Project Name: Loft Cados

Project Address: 30 Merrill Str.

Site Plan ID Number: # 2016-172

Project Name: Loft Condos  
Address: 30 Merrill Street  
Applicant: Banner Properties, LLC  
Planner: Nell Donaldson

Subdivision Recording Plat 30 Lofts Condominium

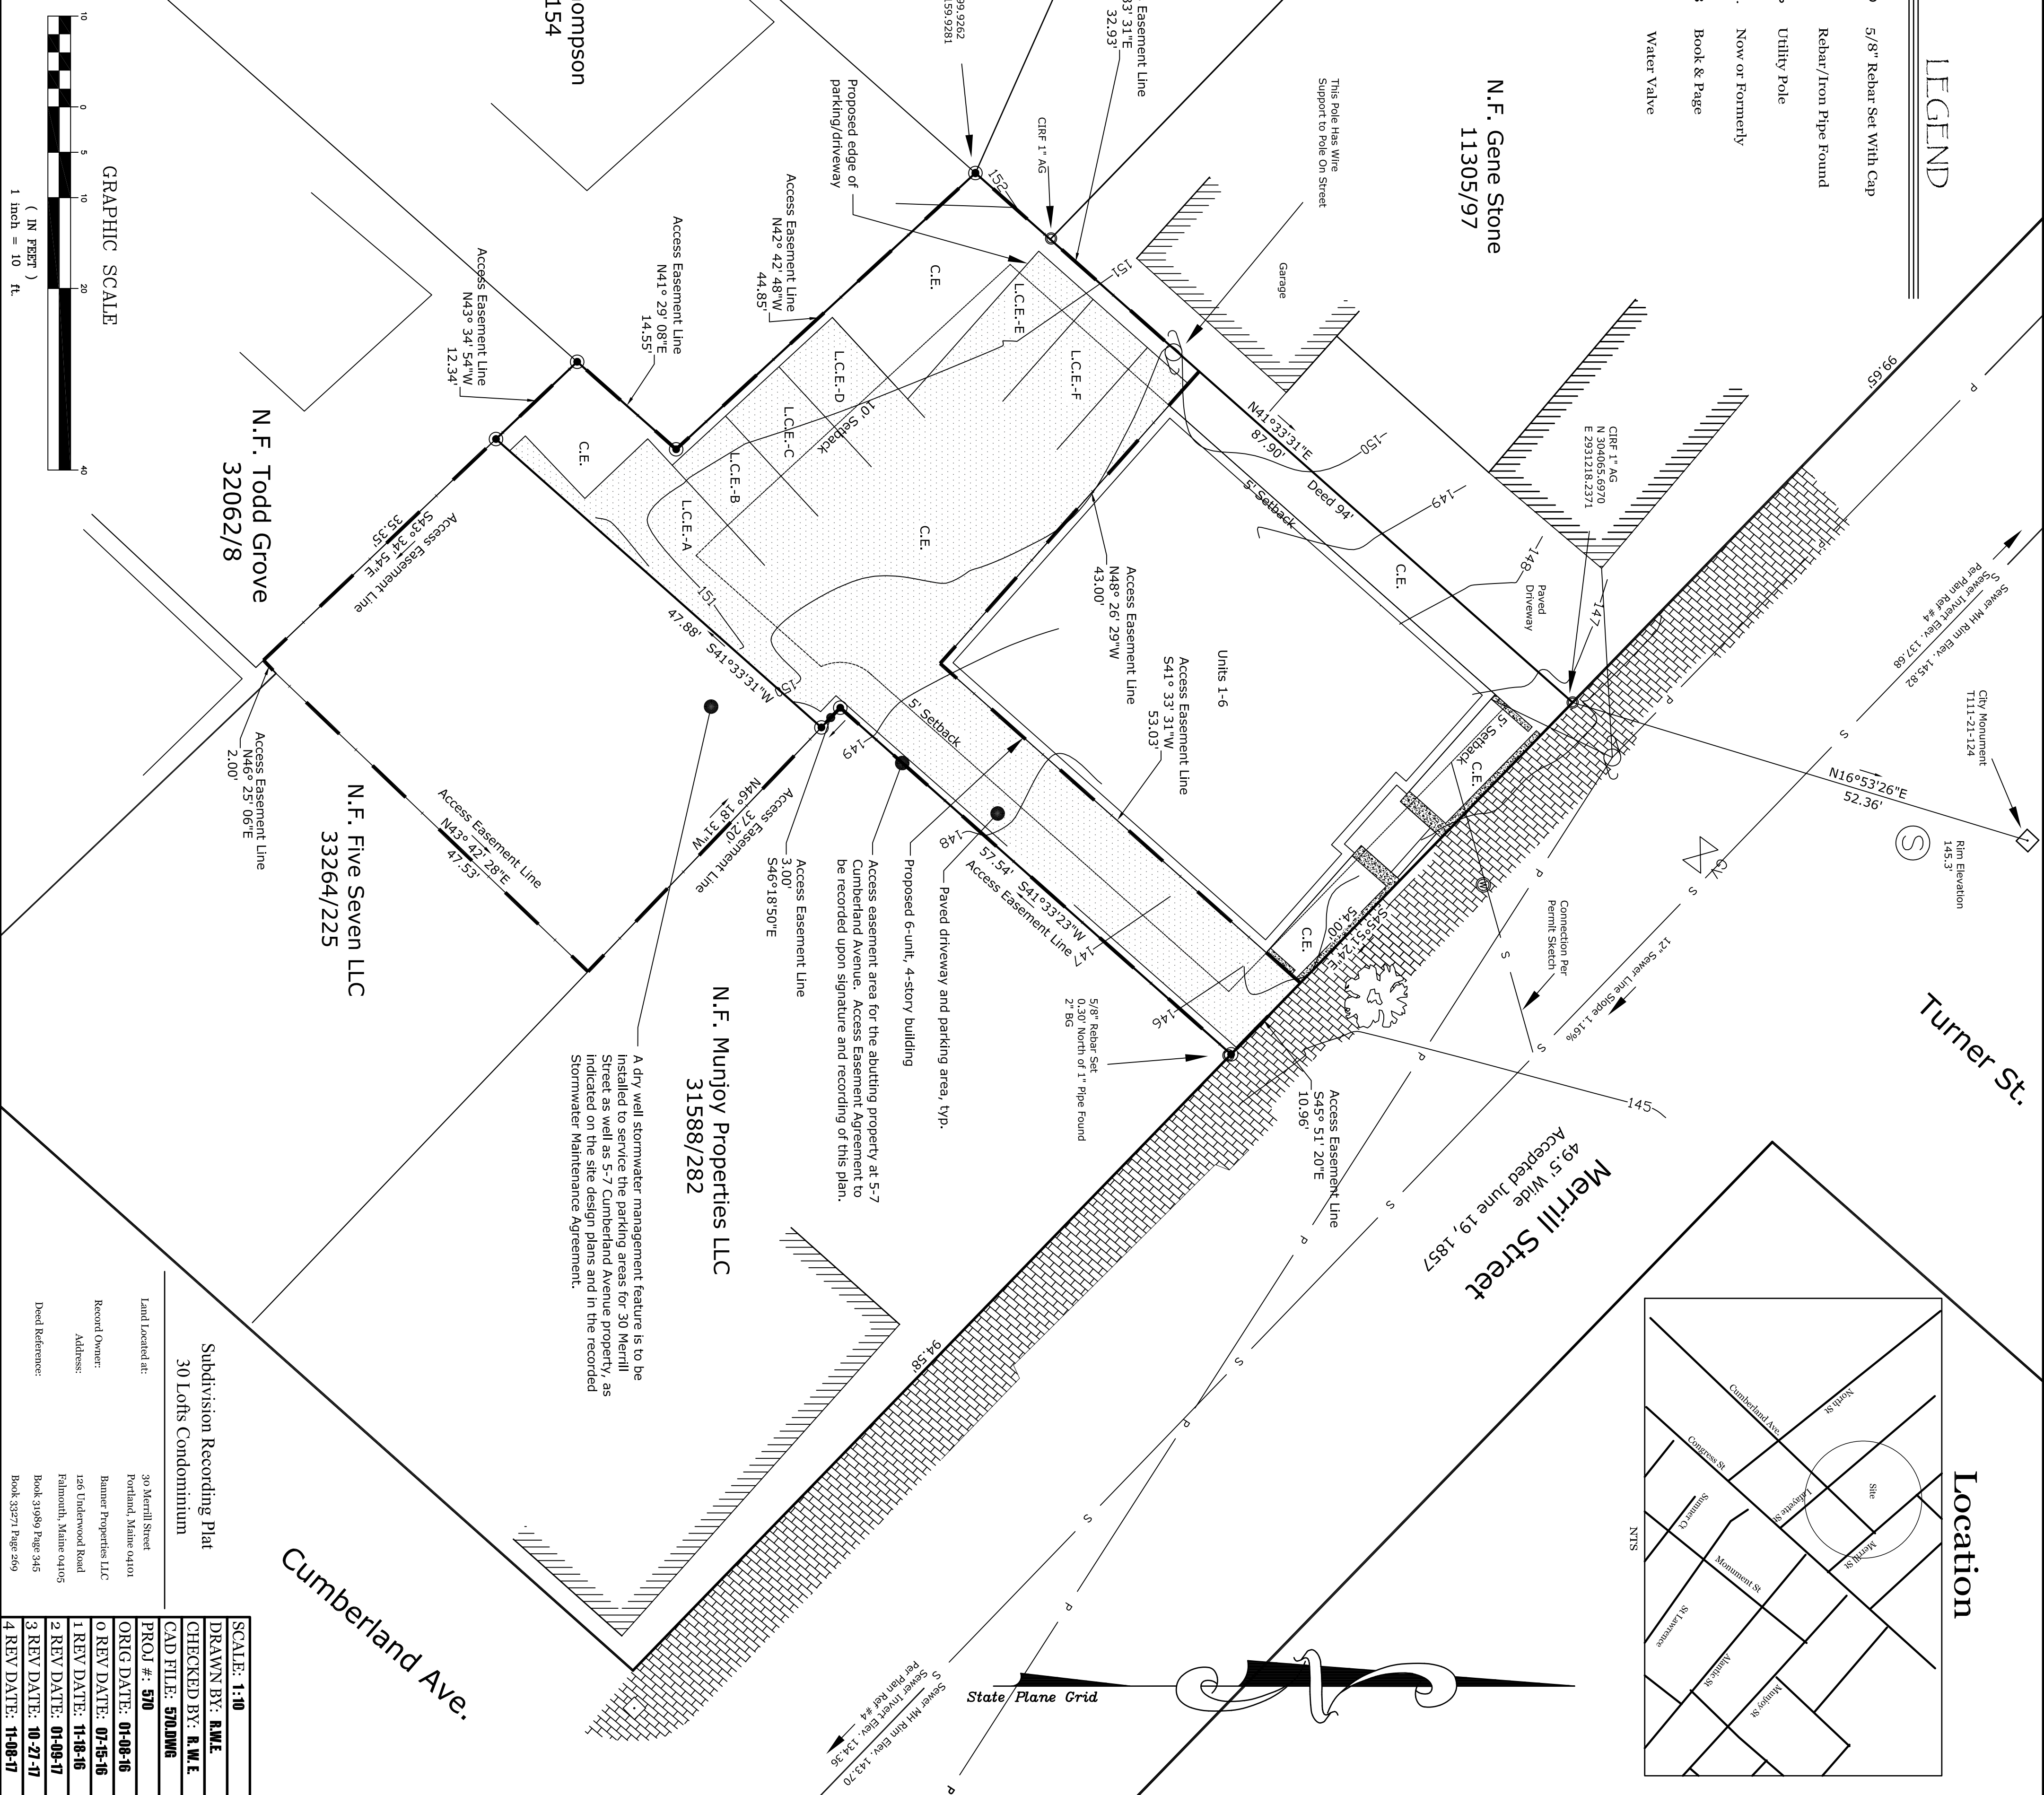
Re the ADA parking, it is okay to make that change, given that our reviewers have signed off on this approach for 5-7 Cumberland. That said, I don't believe the condo docs you've submitted for 30 Merrill address the question of accessibility in a manner parallel to that for 5-7 Cumberland? Doublecheck and let me know if I'm wrong. As I mentioned before, the changes in the parking arrangement should be represented on the revised plat (and we need to confirm the landscaped open space requirement is still being met).

The other item is making sure the easement is shown on the plat (both in terms of location on the ground and in the notes, with a space for recording details).

I will get in contact with our Civil Engineer and discuss the plats and Maintenance Agreements for both projects. I will also take a look at the Condo docs for 30 Merrill and make sure they align with what we have stated at 5-7 Cumberland. I will have him confirm the open space percentage, and get the easement shown on the plat with metes and bounds.
